# A303 Sparkford to Ilchester Dualling Scheme TR010036

## 8.6 Draft Statement of Common Ground with Somerset Drainage Board Consortium

**DRAFT STATEMENT OF COMMON GROUND**

A303 Sparkford to Ilchester Dualling Scheme TR010036

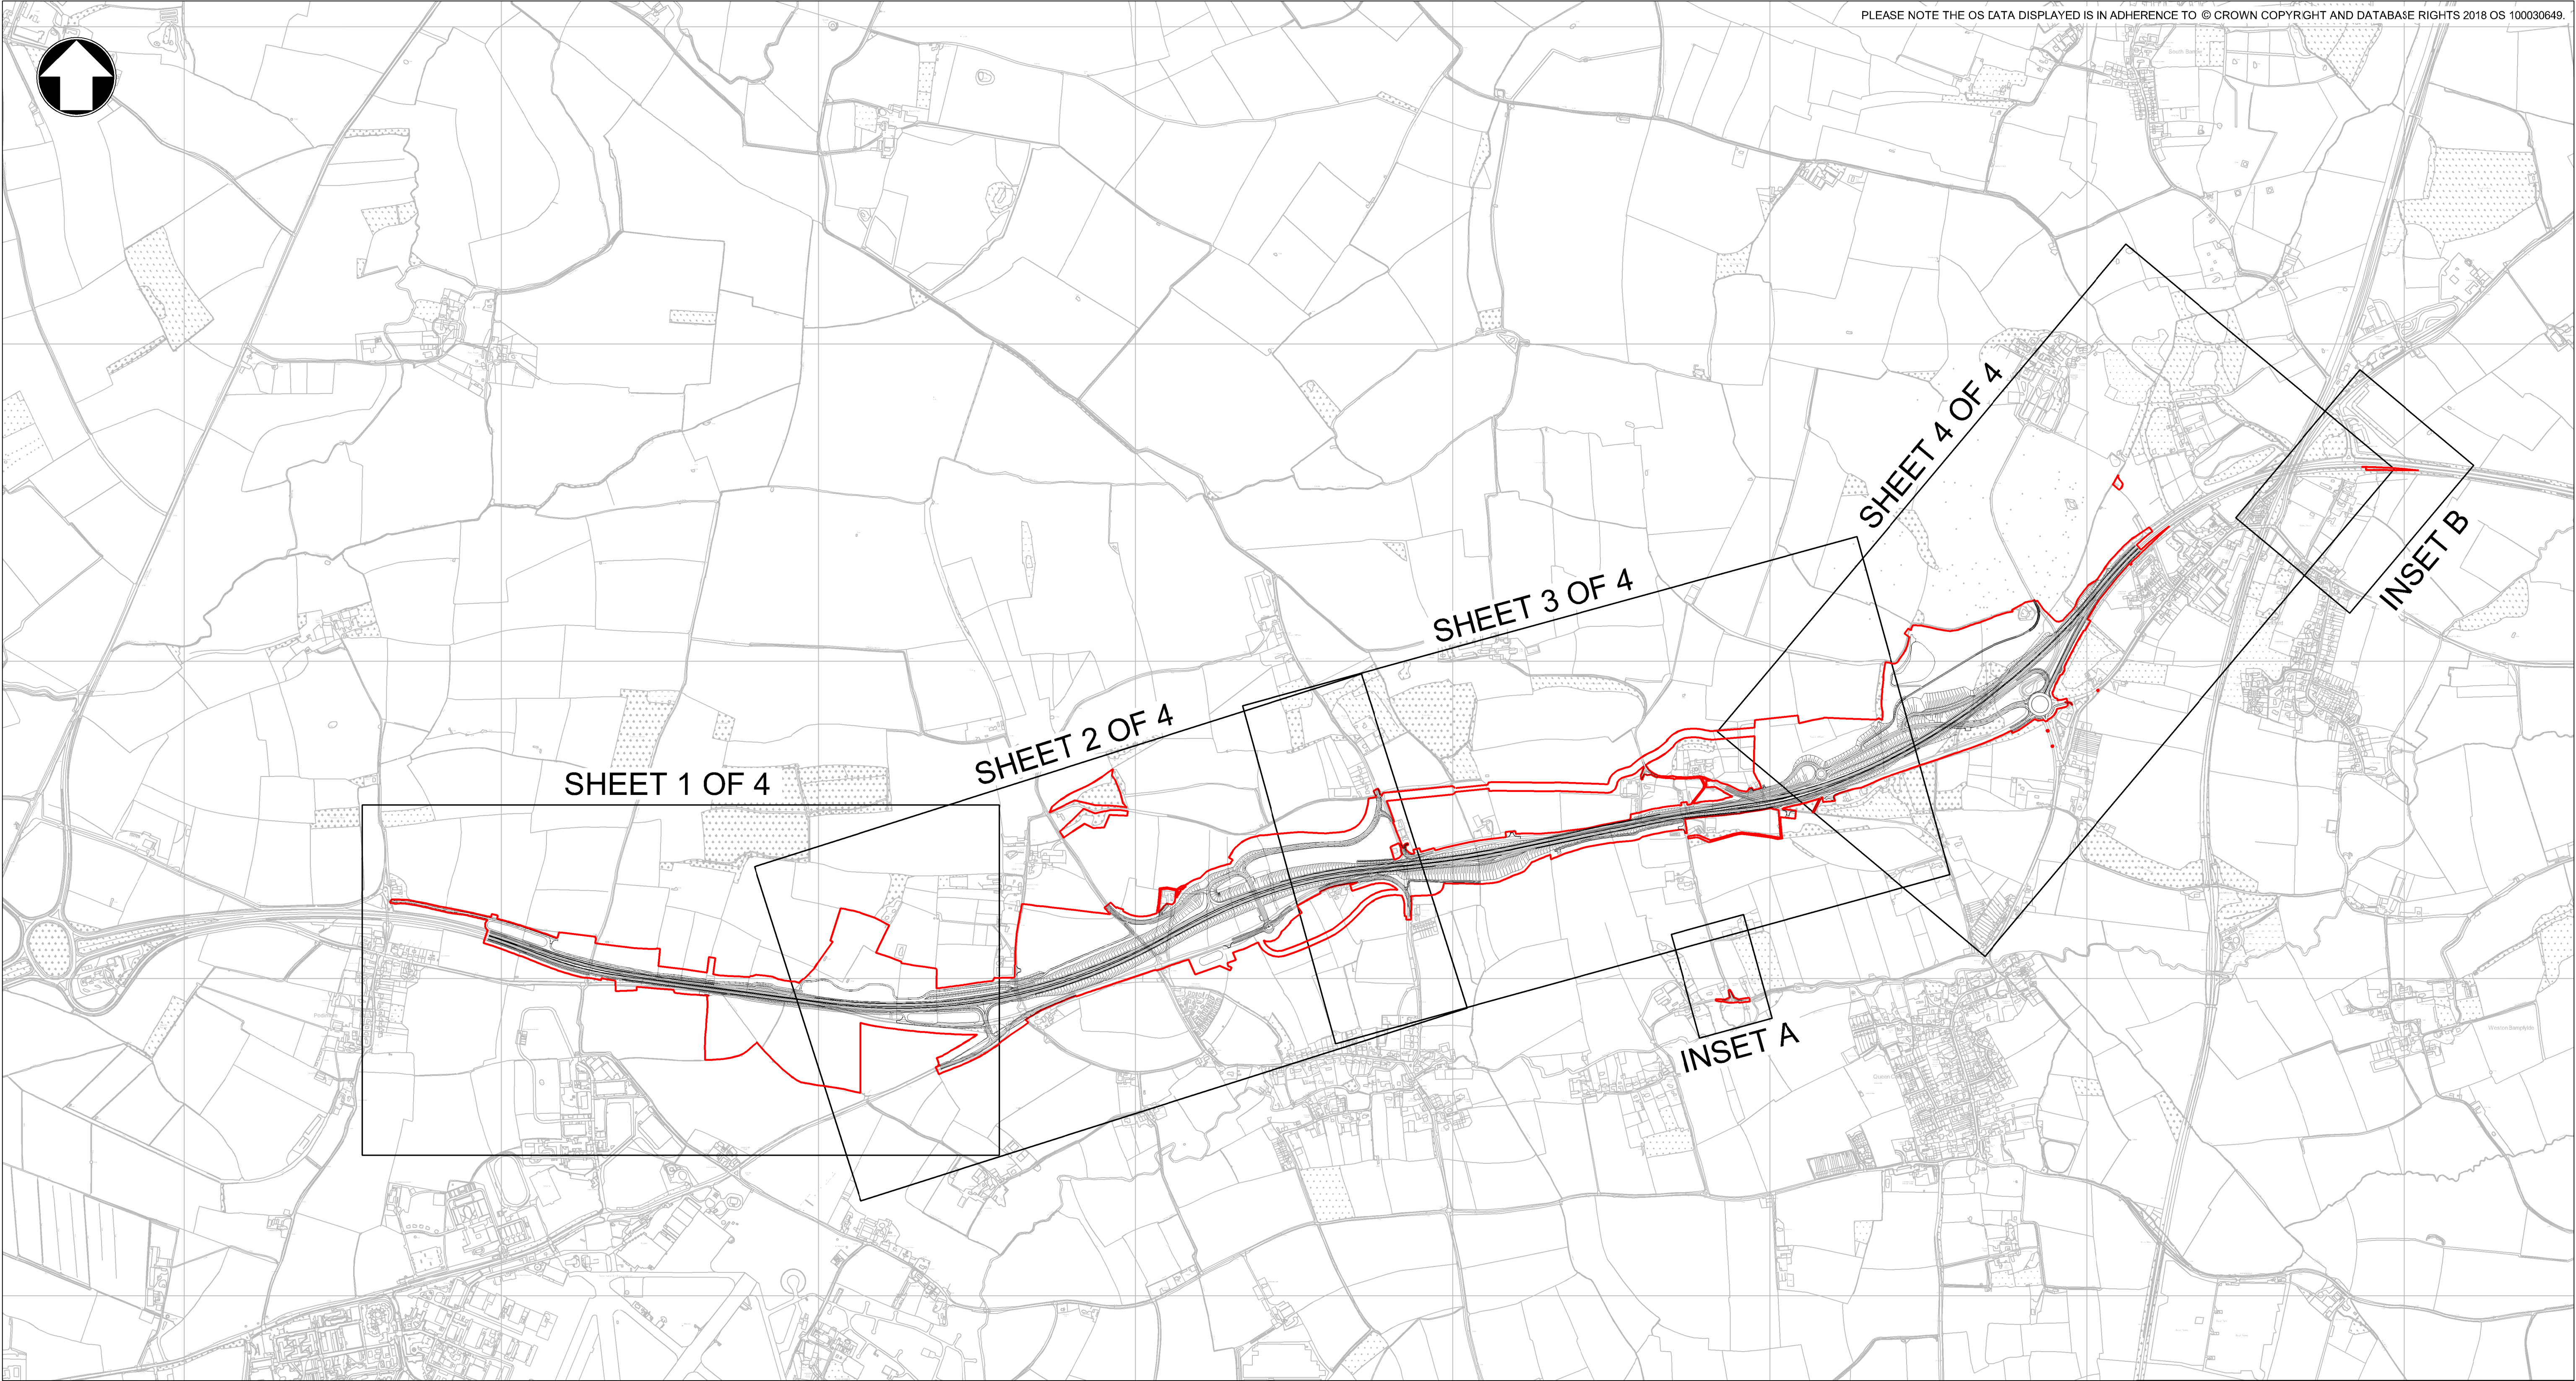
Topic	Stakeholder Comment	Highways England Response	Status
Water quantity	Confirmation is sought that the proposed design will control the overall volume, as well as the overall rate of runoff with sufficient attenuation provided.	Attenuation has been provided, with discharge limited to 1% annual exceedance probability (1 in 100-year event) plus 40% to account for the effects of climate change (Flood risk assessments: climate change allowances, Environment Agency), to no greater than the undeveloped rate of runoff, determined by the calculation of the mean annual peak rate of runoff for a greenfield site (Qbar).  Preliminary design discharge rates and volumes shown in Outline Drainage Works Plans (APP-106).	<b>AGREED</b>
Water quality	Confirmation is sought that the proposed pond design provides effective water quality treatment with the use of a permanent water level, and that this volume is sufficient in size.  It is recommended that the SuDS Manual (C753) is referred to in the calculation of these permanent volumes, as well as the detailed design of the forebays and vegetation that will be essential for water treatment.	A permanent water level has been provided for each of the proposed ponds. The volume of treatment has been provided in accordance with the SuDS Manual (C753) - '10-15 millimetres of rainfall depth falling over the contributing catchment'.  Accepted.  Appropriate planting has been considered as part of the landscaping assessment and design.  Attenuation feature discharge rates and volumes shown in Outline Drainage Works Plans (APP-106).	<b>AGREED</b>

Topic	Stakeholder Comment	Highways England Response	Status
		As in accordance with Outline Drainage Works Plans (APP-106).	
Maintenance and access	<p>There is concern that there is not adequate space provided for adequate and effective maintenance of the ponds and ditches.</p> <p>It is recommended that maintenance tracks are provided, ensuring connectivity to the ponds and ditches.</p> <p>To undertake a full de-silt of the ponds a maintenance strip greater than 4m is required. Further information needs to be supplied on this at the detailed design stage.</p>	<p>A grassed 4 metre maintenance strip has been provided around each pond and along each ditch. Additional access tracks have been provided to provide access to the ponds.</p> <p>As in accordance with Outline Drainage Works Plans (APP-106).</p>	<b>NOT AGREED</b>
	<p>There is concern that the maintenance tracks do not provide access to the control structures, which would need to be maintained and accessed in the event of a large pollution incident.</p>	<p>Accepted.</p> <p>The ponds and maintenance tracks have been redesigned to provide access to these structures.</p> <p>Access shown in Outline Drainage Works Plans (APP-106).</p>	<b>AGREED</b>
